SUBMISSIONS REPORT

URBNSURF Sydney Event Hill Modifications

State Significant Development Modification 07 - (SSD-7942-MOD-07)

10/07/2026

PLANT SCHEDULE

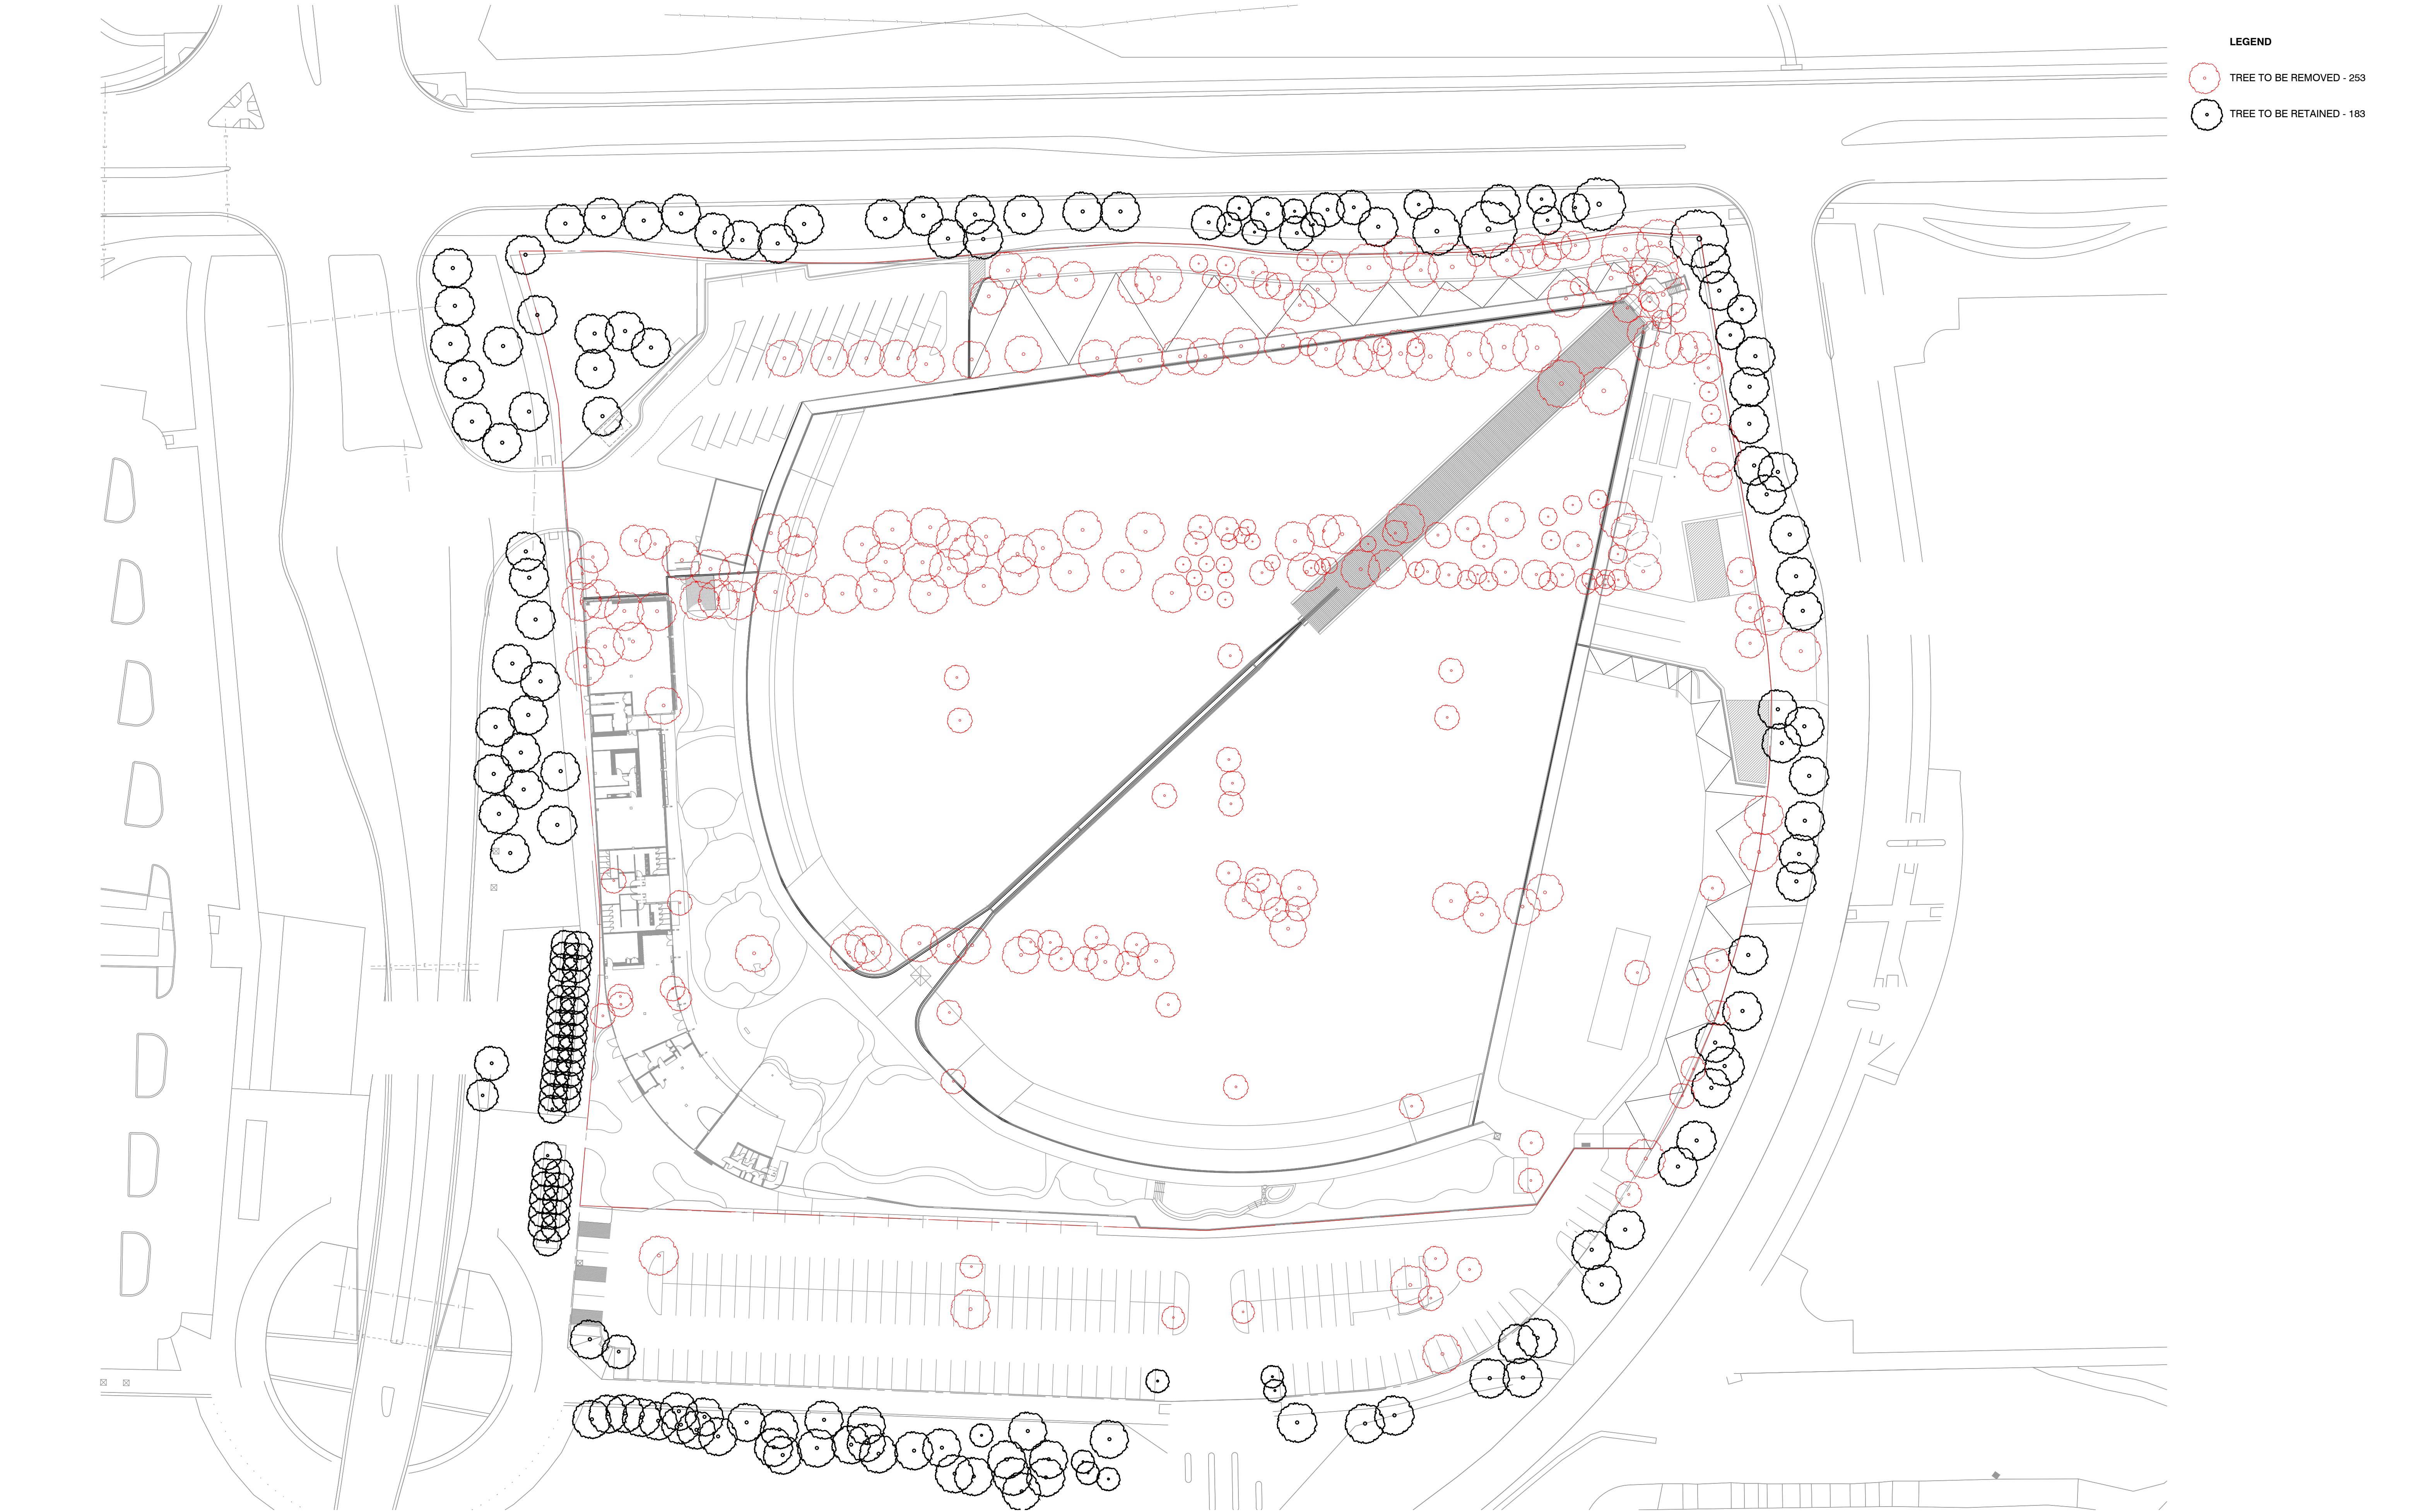
4	Provide a planting schedule detailing any new plantings across the site, including the Events Hill, ensure sufficient topsoil depth is provided on the hill to allow for healthy plantings.	A planting schedule was previously provided as part of the DA Modification submission, with revision clouds identifying the proposed species for the Events Hill. In response to SOPA's request, detailed planting plans have been prepared in attachment B and submitted to illustrate the proposed planting arrangement.	Attachment B

DRAWING
**TREE RETENTION AND
REMOVAL PLAN**

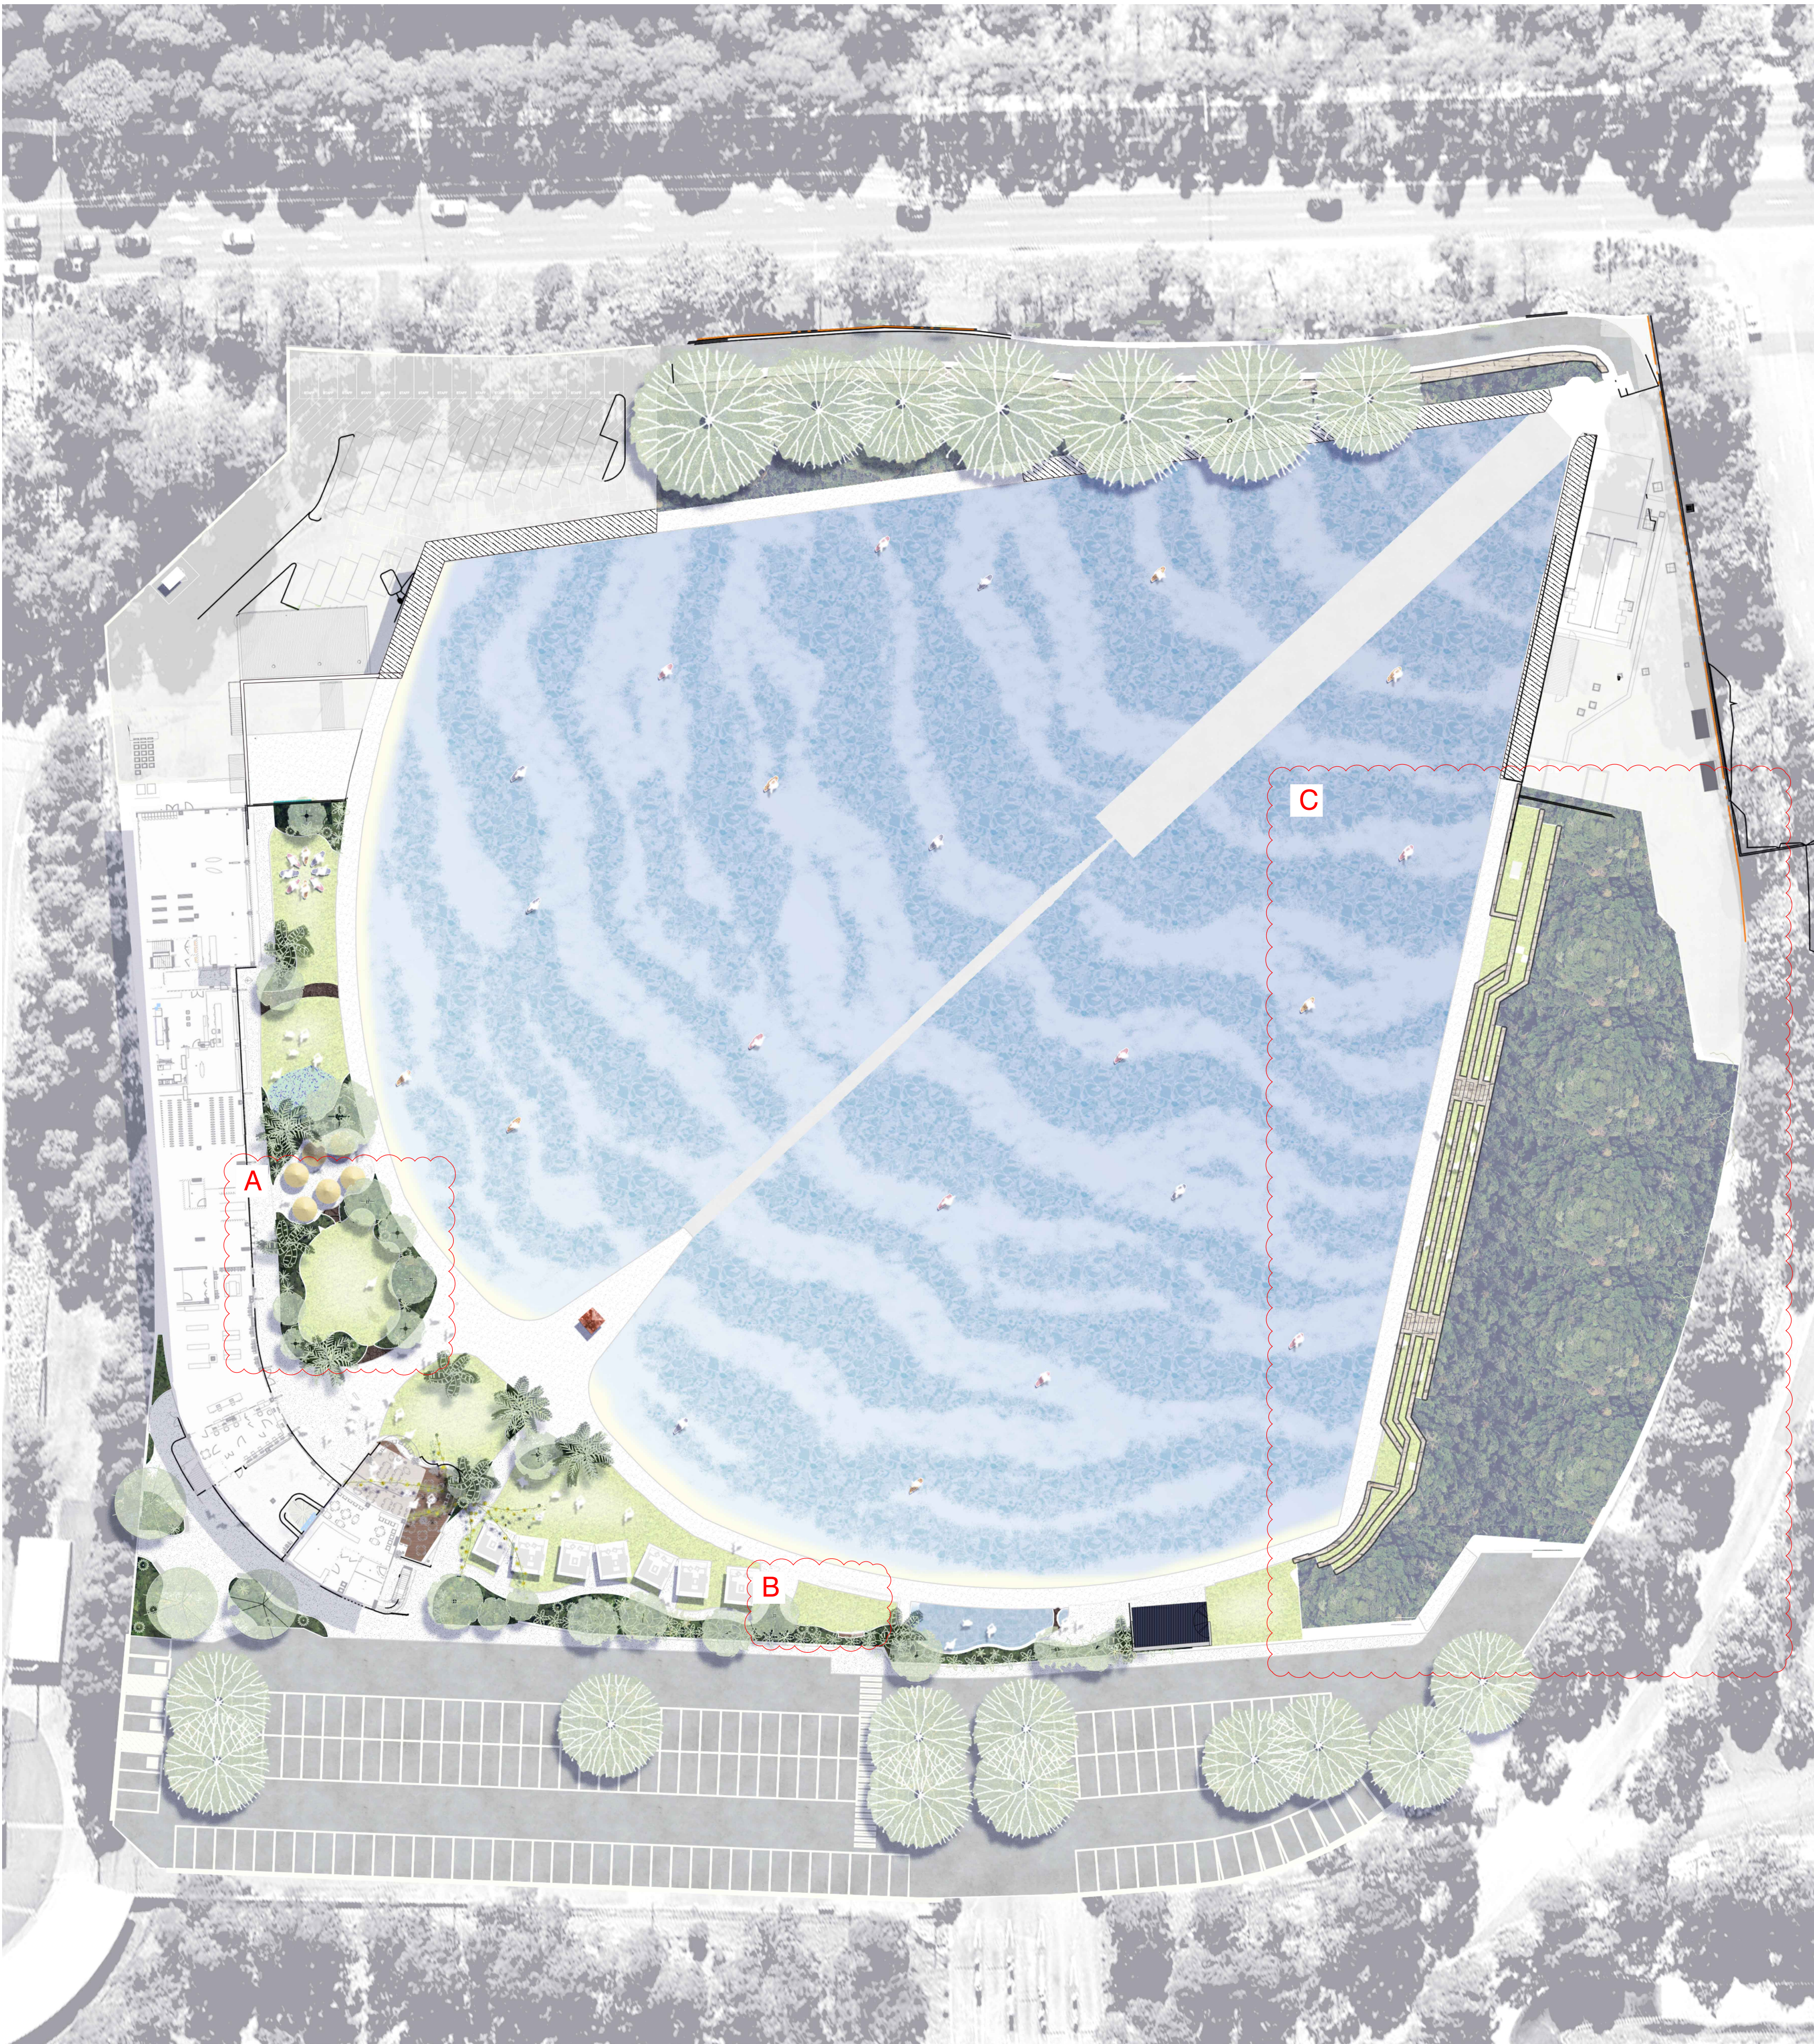
Ref	Issue Raised	Response to Submission	Attachments
3	Justify the removal of 6 large trees on the northeastern boundary of the site from the previously approved landscape plans	The approved landscape plans dated 29 October 2021 included six proposed trees along the north-eastern site boundary to provide natural screening to the event space adjacent to the lagoon. During the construction phase, additional areas of contaminated soil were identified requiring remediation and capping on-site. Following detailed site investigations and remediation planning with consultant team, the northern batter and event lawn area were determined to be the only suitable locations available to accommodate the required capping works. As a result, the previously proposed flat event lawn area was regraded to form a 1:3 batter. In accordance with the geotechnical engineer's requirements, the batter comprises a geotextile layer, 150 mm of VENM, a maximum 200 mm capping layer, and 150 mm of topsoil to provide slope stabilisation and environmental protection. Due to the limited soil depth available above the capping system, the area is not capable of supporting the long-term establishment and growth of trees. Accordingly, the six proposed trees have been removed from this location. The revised landscape design instead utilises mass planting to provide visual screening, maximise vegetation coverage. This approach responds to the revised site conditions while maintaining the original landscape intent of providing a vegetated buffer along the site boundary.	Attachment B
